WOODMEN HILLS METROPOLITAN DISTRICT

LIFT STATION #1 REPLACEMENT

WOODMEN HILLS METROPOLITAN DISTRICT
LIFT STATION #1 REPLACEMENT
OVERALL PROPOSED SITE PLAN

C1

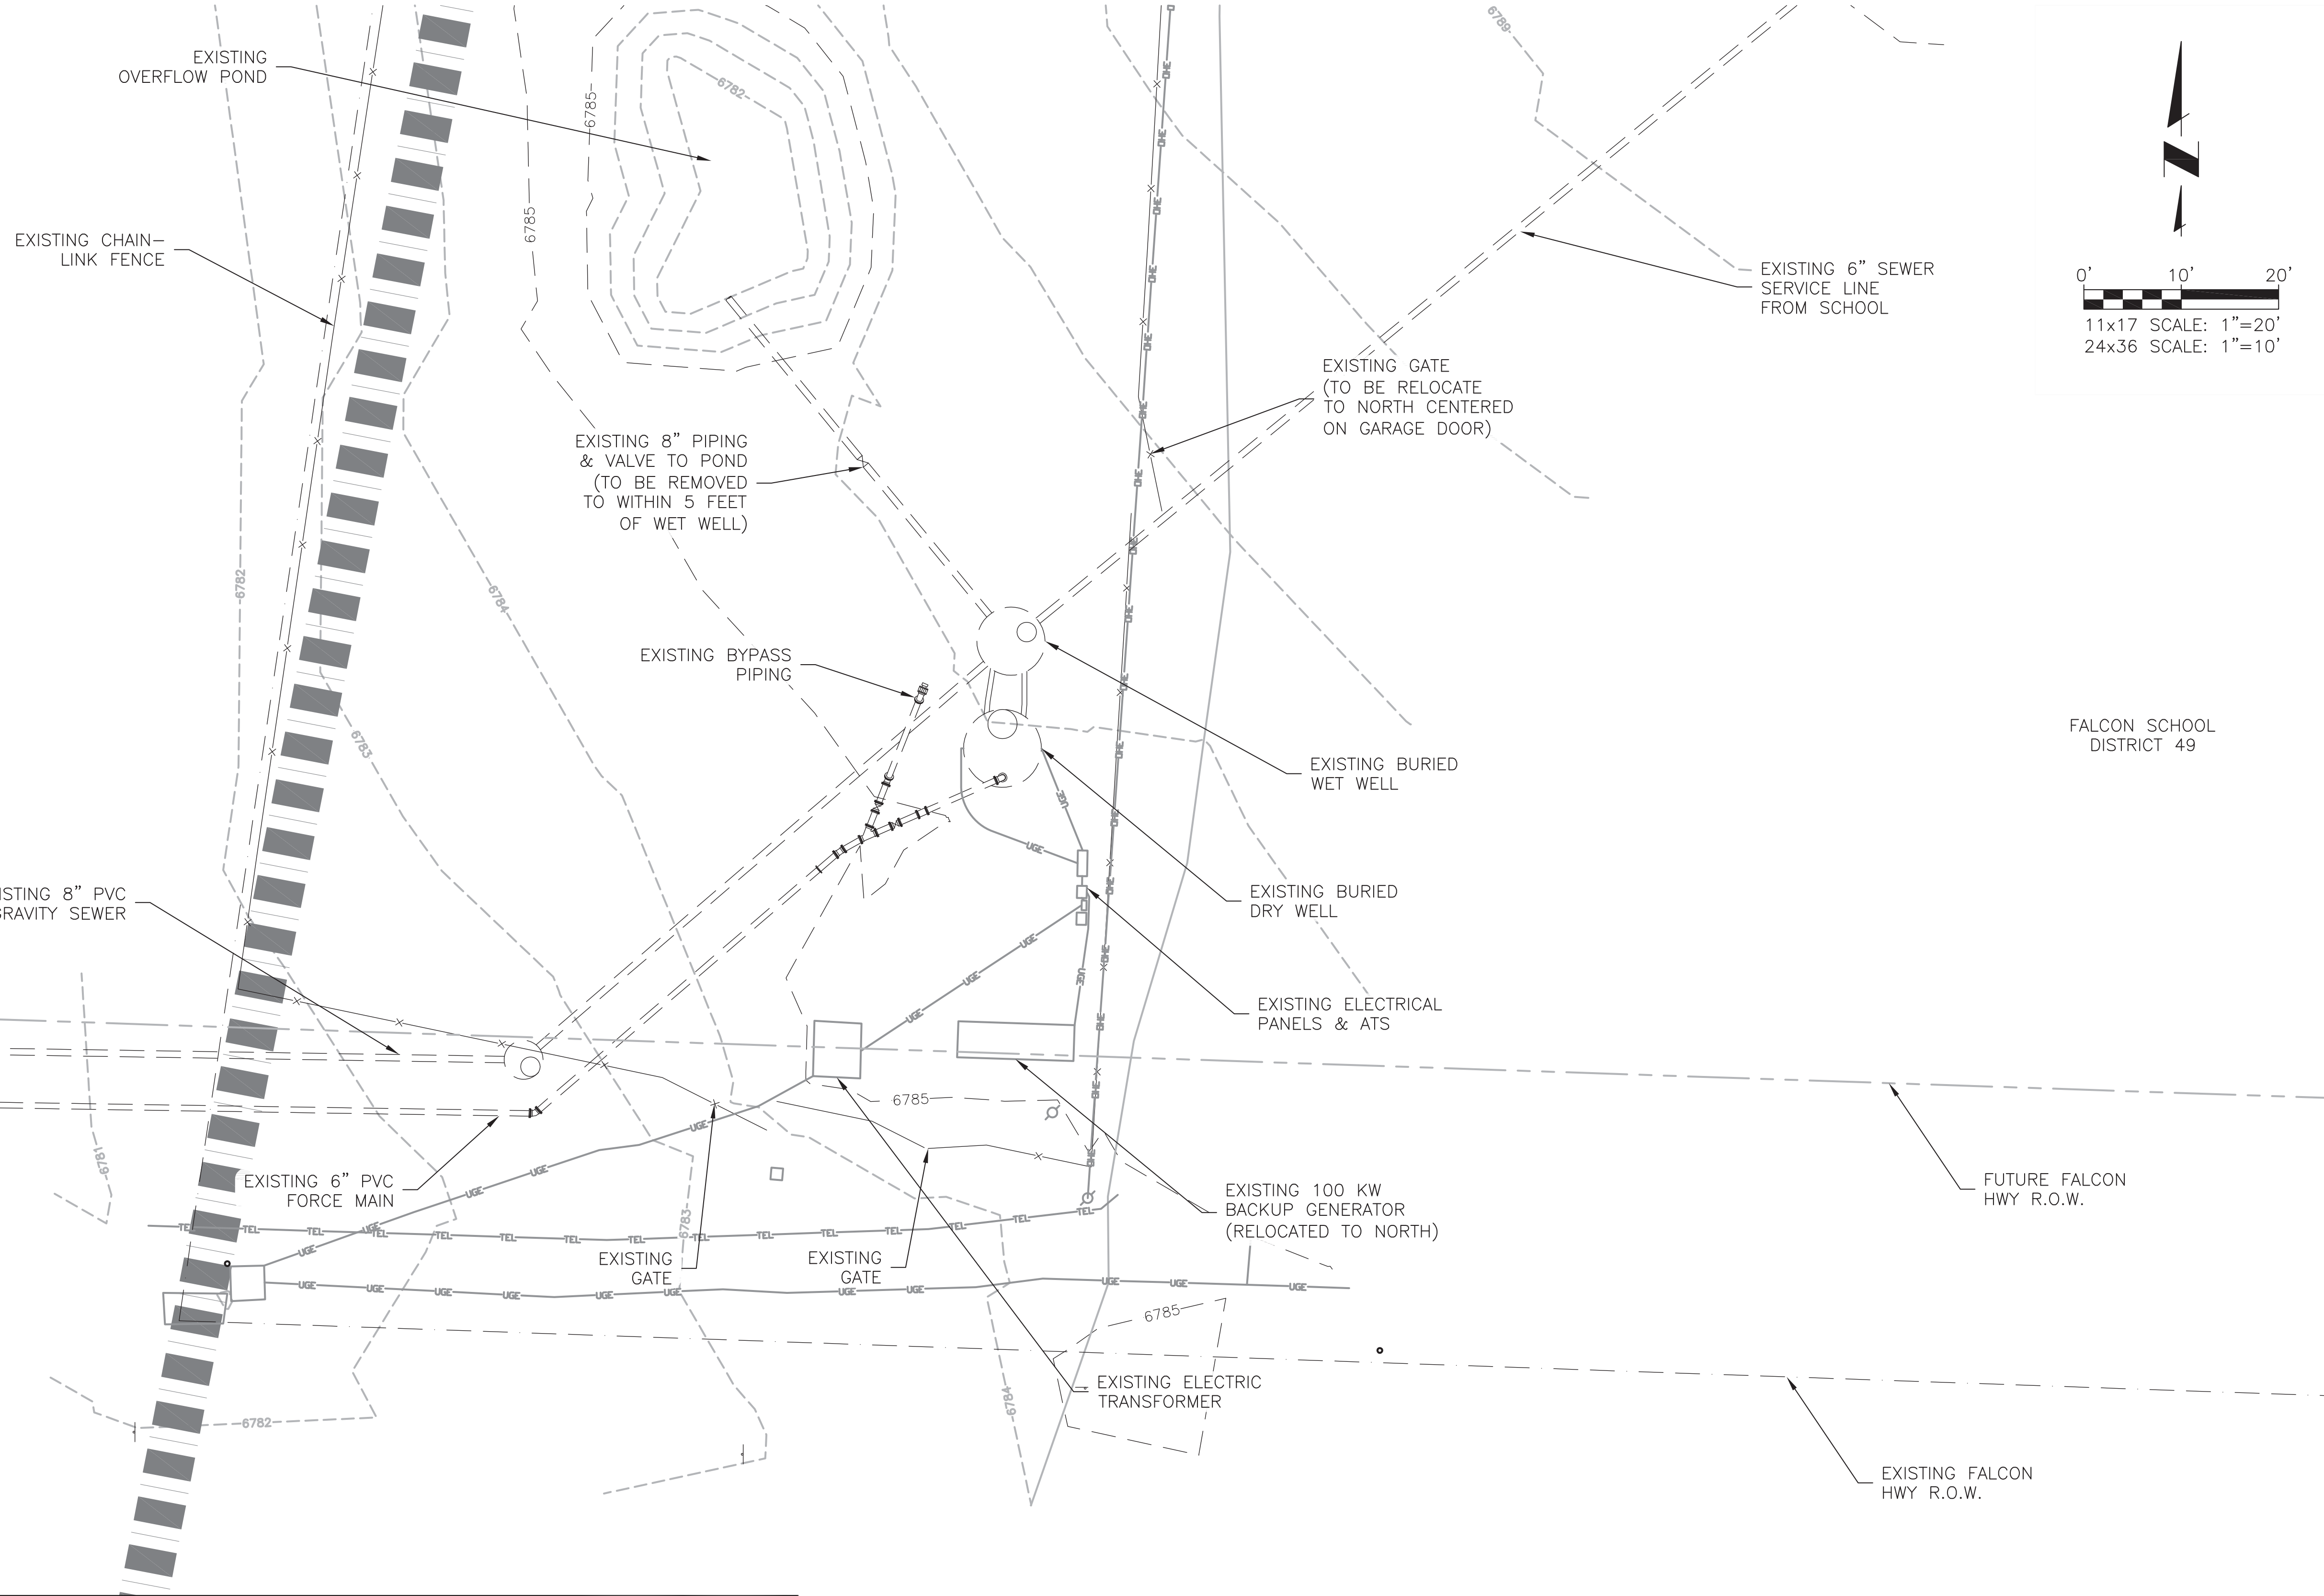
Add PCD File No. PPR1841

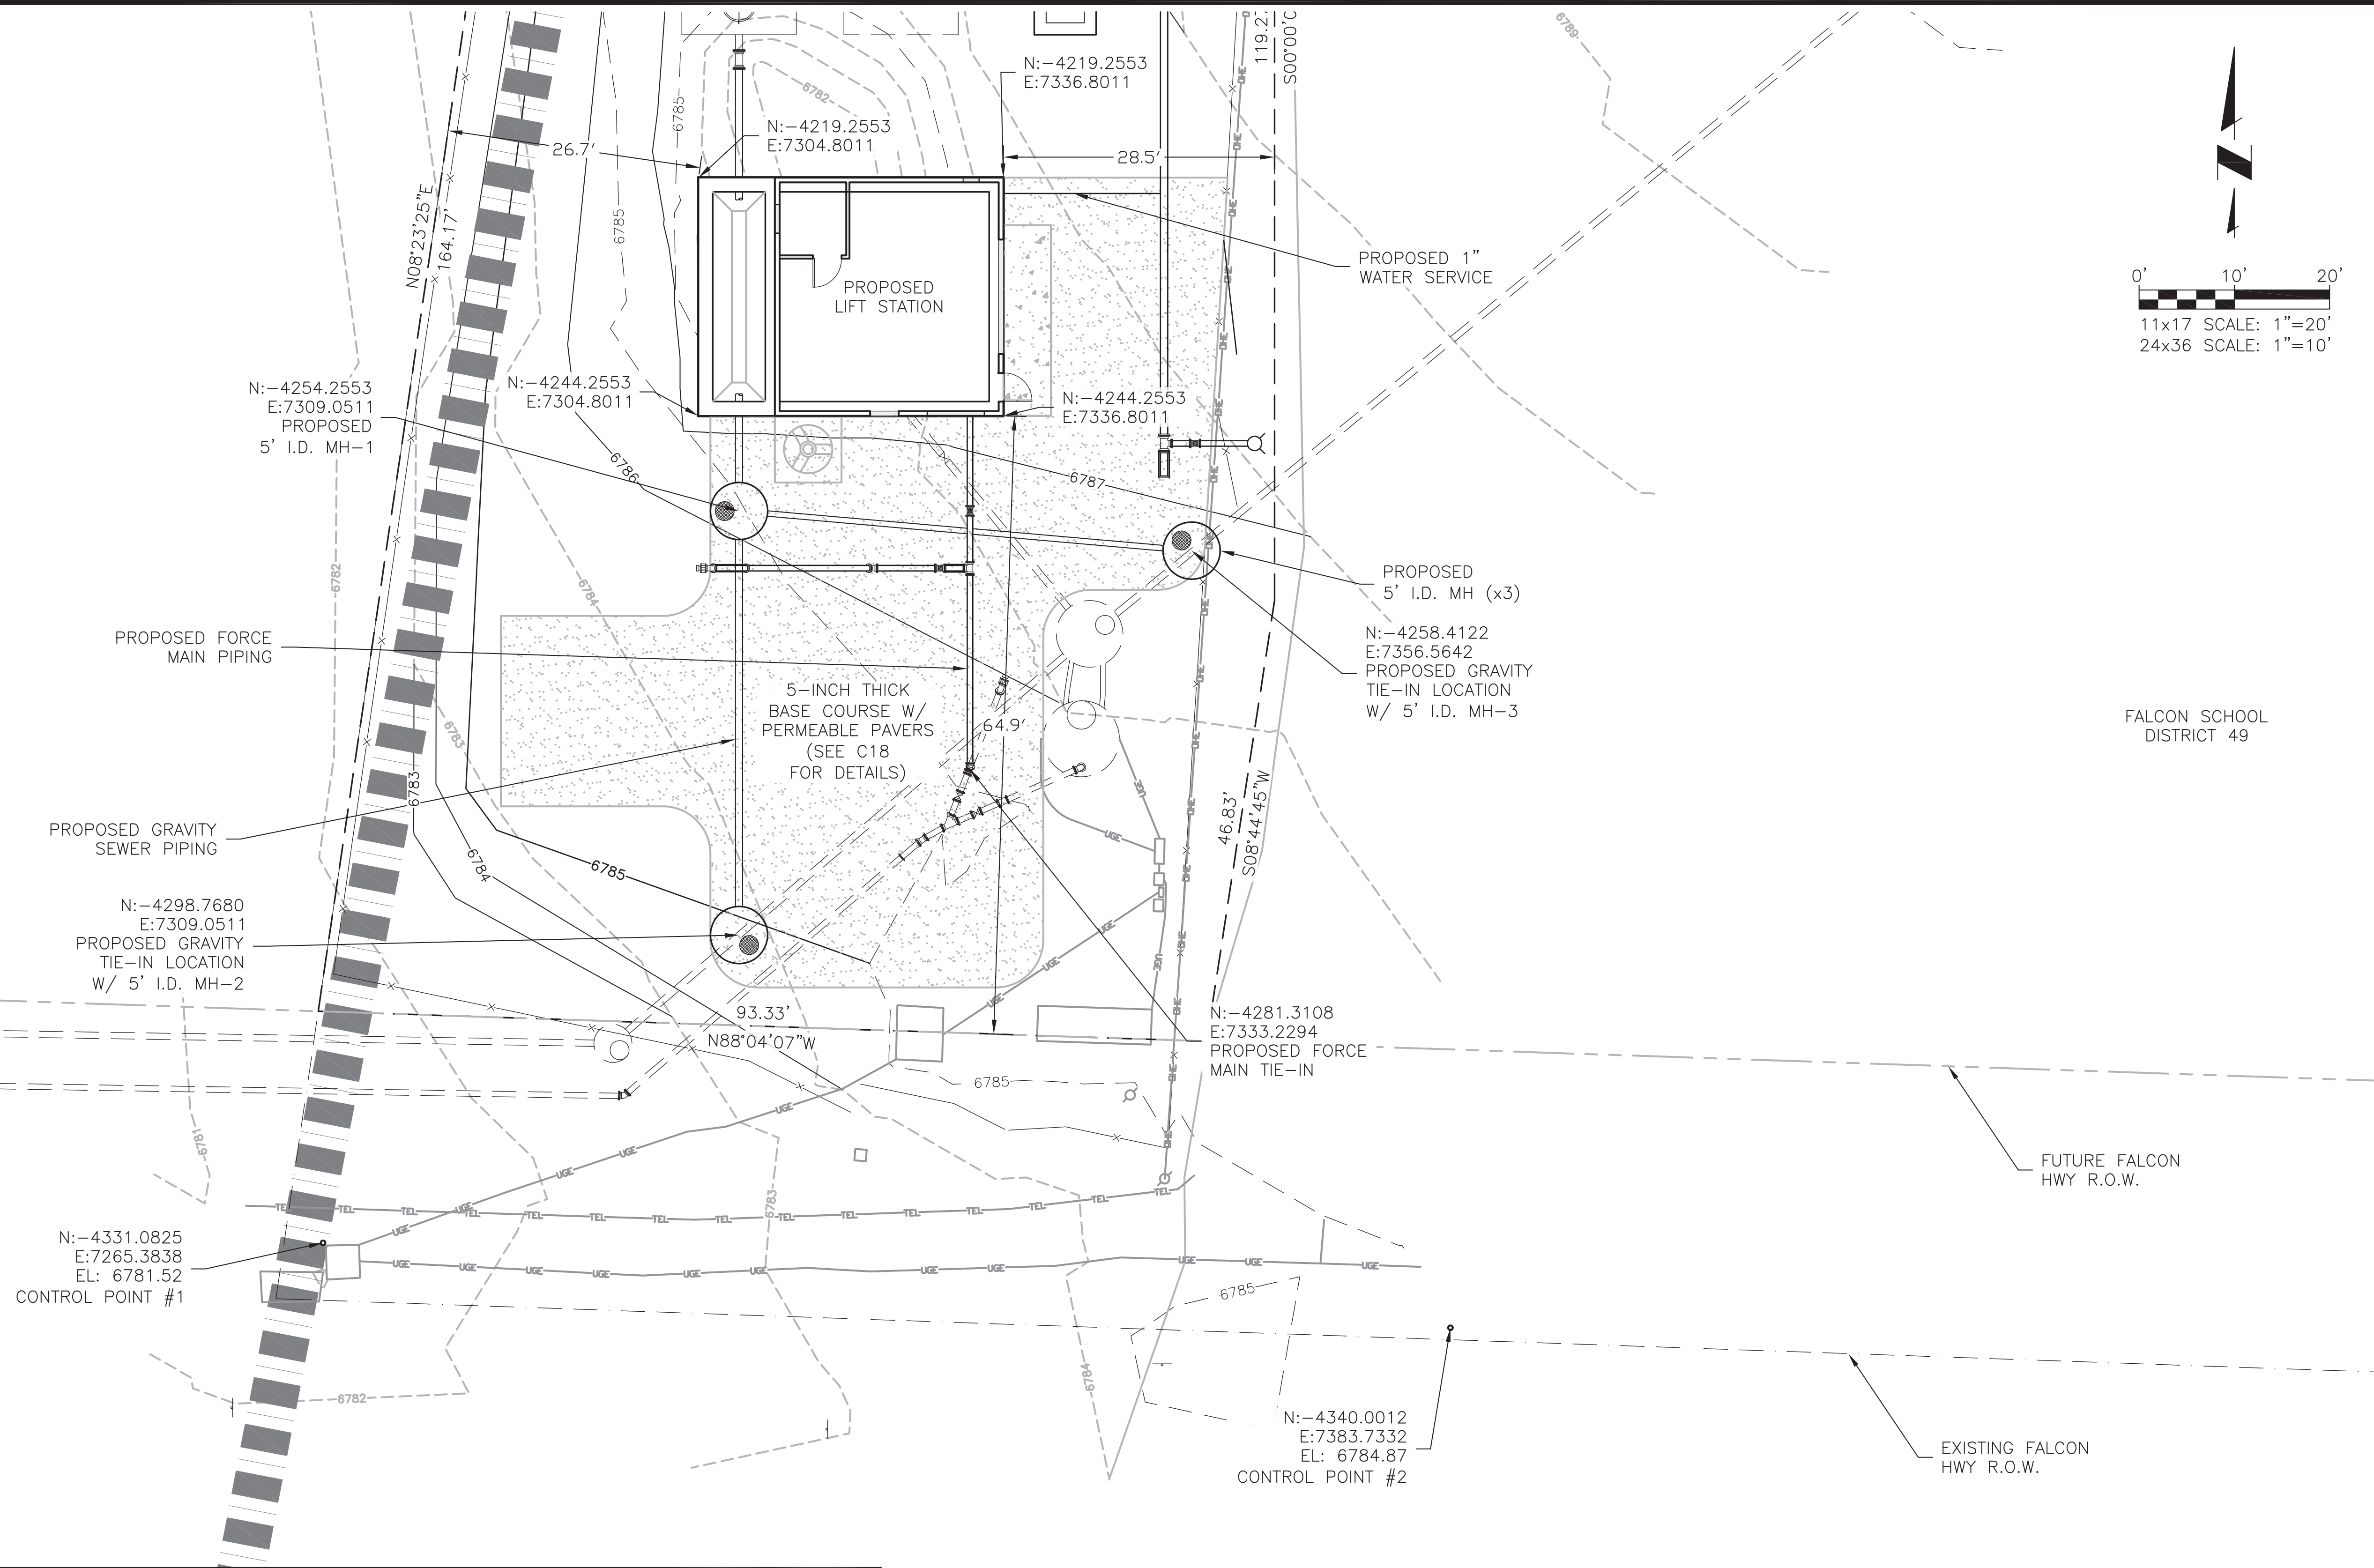
Provide dimension of all easements.

Identify adjacent property owners by name or platted subdivision name.
Provide this on all site plan sheets

Show the FEMA flood plain on the plan.
Provide this on all site plan sheets.

Provide a vicinity map.

Provide dimensions from all facilities to the closest property line.

•Provide legend and/or label various line types. Provide on all site plan sheets.

Show the setback distance from the property lines

Include this note on the plan.

The parties responsible for this plan have familiarized themselves with all current accessibility criteria and specifications and the proposed plan reflects all site elements required by the applicable ADA design standards and guidelines as published by the United States Department of Justice. Approval of this plan by El Paso County does not assure compliance with the ADA or any regulations or guidelines enacted or promulgated under or with respect to such laws.
